Appendix B: Summary of and Responses to Public Submissions

**SITE SECTION 2**

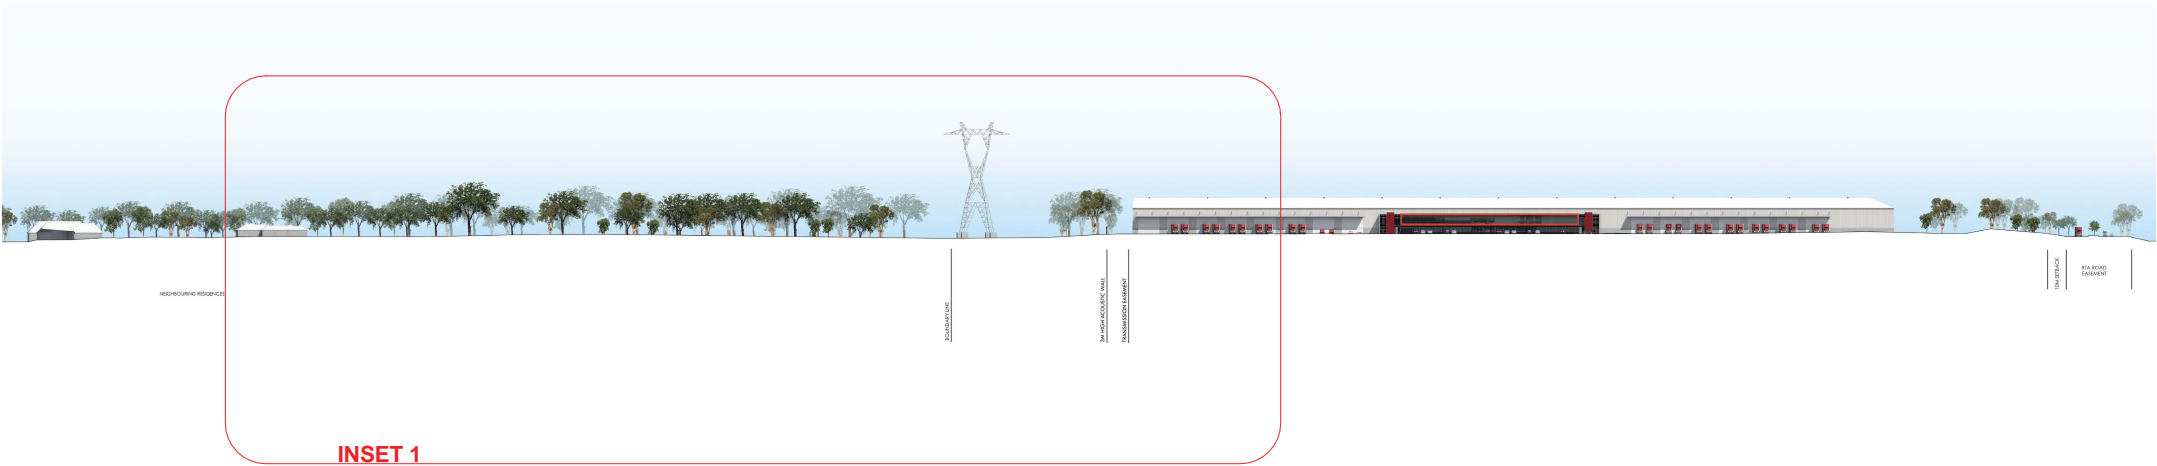
Noise	According to the plans, there will be trucks driving alongside the fence line (south side) closer to us through all hours of the day/night. We are constantly hearing the sounds of trucks, reverse beepers, forklifts, containers, speakers, PA systems, and even sometimes blaring music being played in the warehouses in the middle of the night, and sometimes until the early morning. We are concerned that Gazcorp Industrial Estate will make an immense impact on our residential noise level. Prior to the DA approval we would like an independent acoustic consultant's report generated factoring in how Gazcorps acoustics will affect us, being only 140m away. Gazcorp has apparently proposed a 3m colourbond fence (with 50mm insulation) to block out the noise, which I believe to be inadequate (the trucks are almost as tall as the wall).	4-7	The noise impact assessment has determined that the night-time project specific noise criteria can be complied with and the that the proposed acoustic barrier on the southern side of the proposed Stage 1 building is suitable for this purpose.

Issue Category	Issue	Submission #	Response
	<p>We are against the trucks driving in and out of the estate 24/7. I note in Gazcorp's proposal that they are proposing a 6 foot colourbond fence. How is this supposed to make ANY DIFFERENCE to noise. We propose that they build a dirt mound from the Wallgrove Road entrance up to the pigfarm hill then extend all the way down past Flavax lane - with a 6 metre high concrete wall - this MAY reduce the noise to the residence. I suggest a buffer zone - from the southern side of the Gazcorp proposal boundary - right up to the Chanaos Road, Stockmans route. This would solve our issues and provide enough of a buffer to the rest of the residence in Horsley Park ie: Gazcorp to buy out the residential properties they will effect.</p>	31	<p>A mound and masonry wall is not required in relation to addressing noise impact. The Industrial Noise Policy has been used to establish project specific noise criteria for the estate, and a noise assessment has determined that the proposed colourbond fence is sufficient to meet the criteria.</p> <p>If details of future buildings and uses exceed the assumptions set out in the noise report then additional noise modelling and assessment would be required to ensure the project specific noise criteria are met. If necessary, additional noise mitigation measures could be implemented as part of the development of the specific building.</p> <p>Gazcorp has proposed additional landscaping treatment in front of the proposed noise barrier in order to soften its landscape impacts.</p>
